Whalley Parish Council

PLANNING APPLICATIONS 3/2016/0247

PROPOSED GROUND FLOOR PLAN

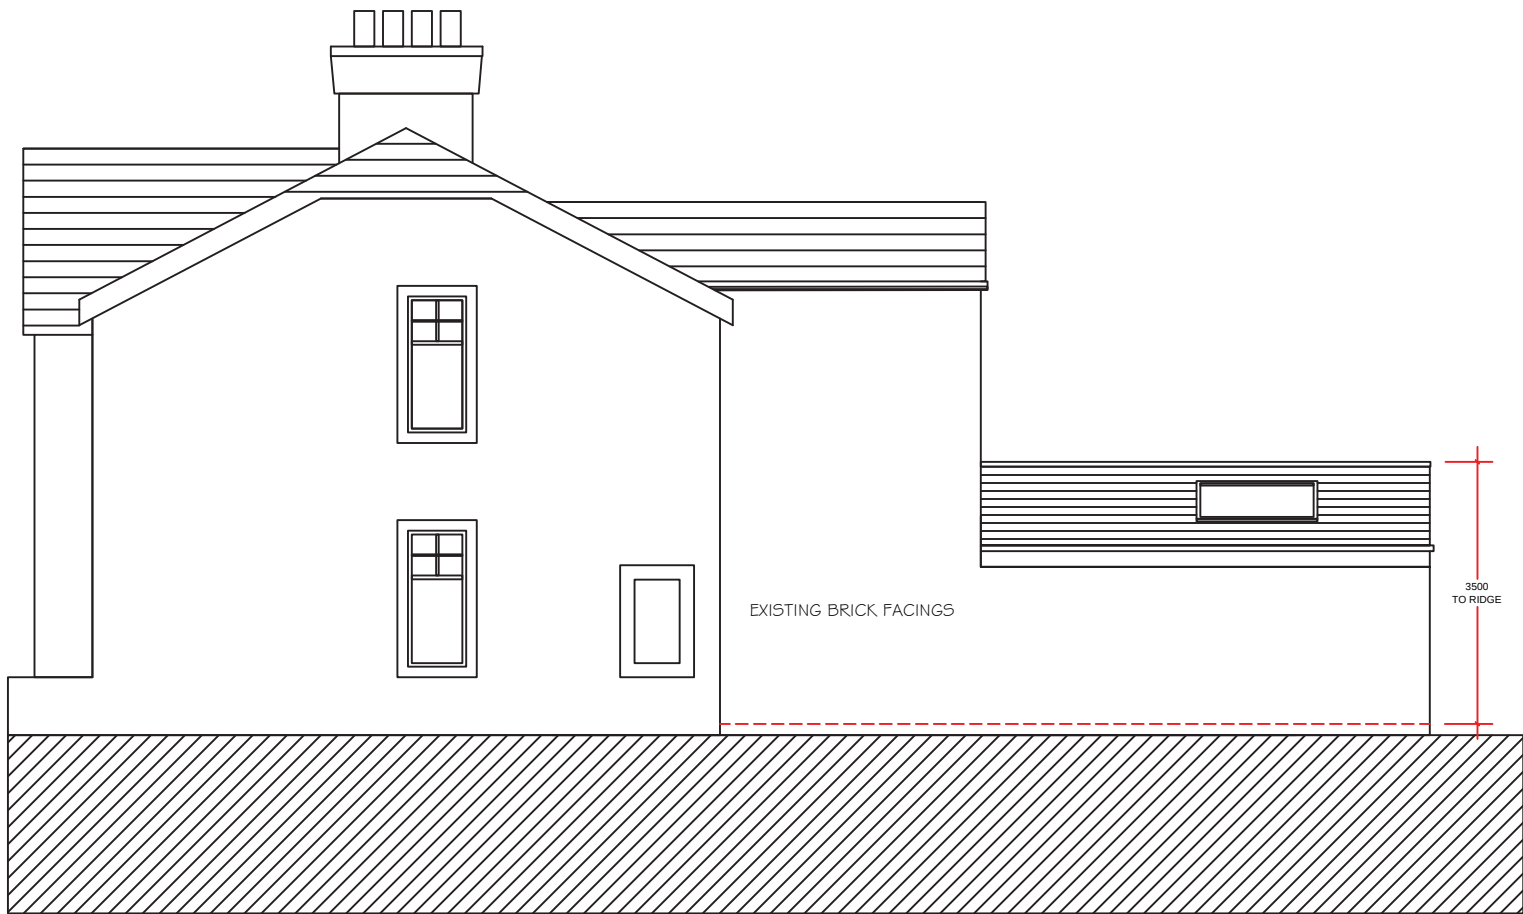
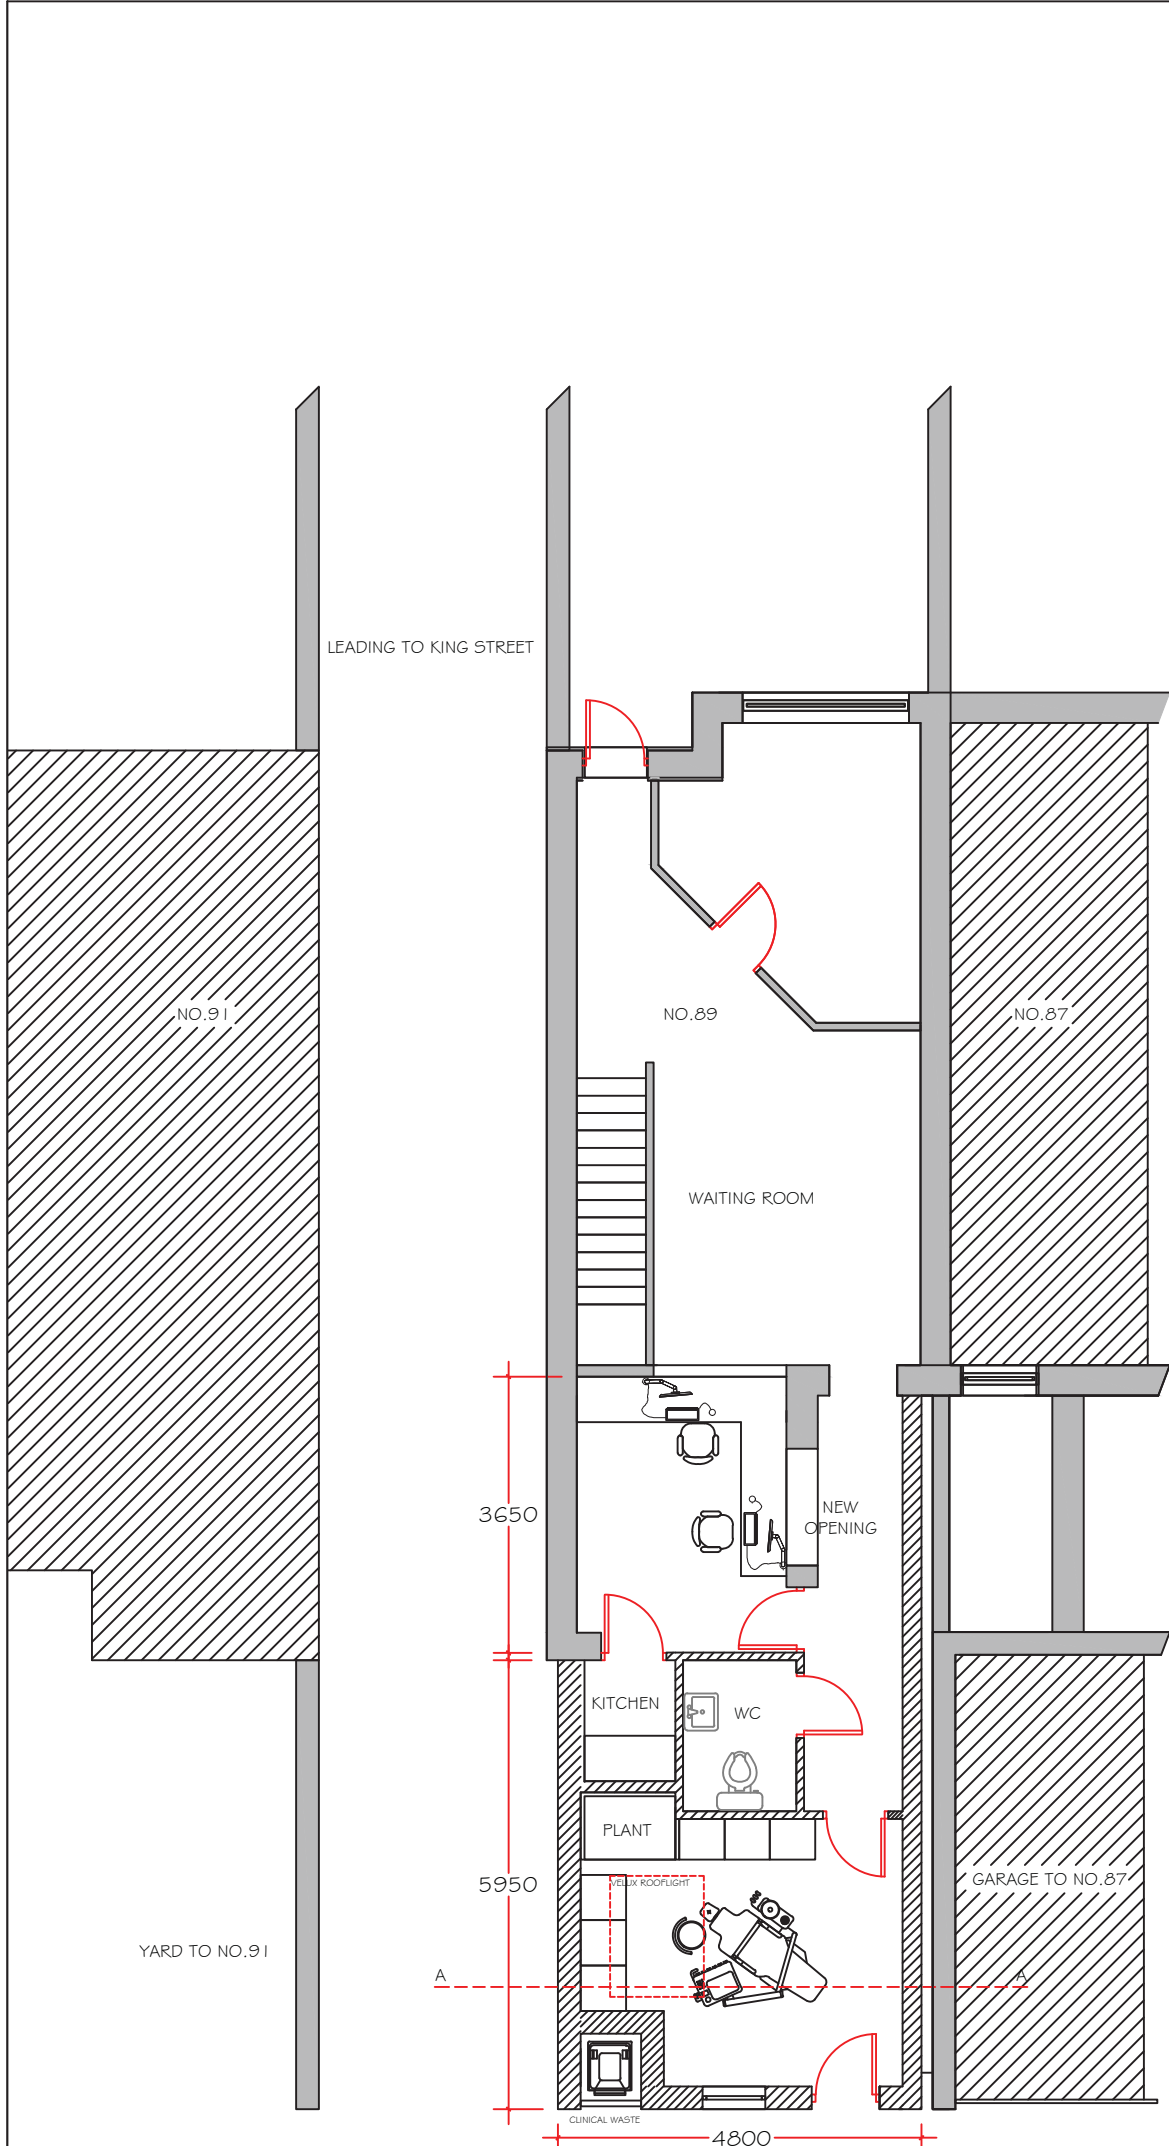
The Parish Council objects to this application. Presently the area to which the applicant wishes to build is used for parking and storage of waste. The resultant displacement of vehicles will have a negative impact. The village centre parking provision is inadequate and this proposal will lead to greater competition for on street parking spaces. This will be to the detriment of local residents and businesses.

The lack of adequate and acceptable waste storage facilities would result in the potential for waste to be stored on the adjacent highway. Following the floods the area has seen an increase in vermin. Creation of an additional food supply would only exacerbate the problem.
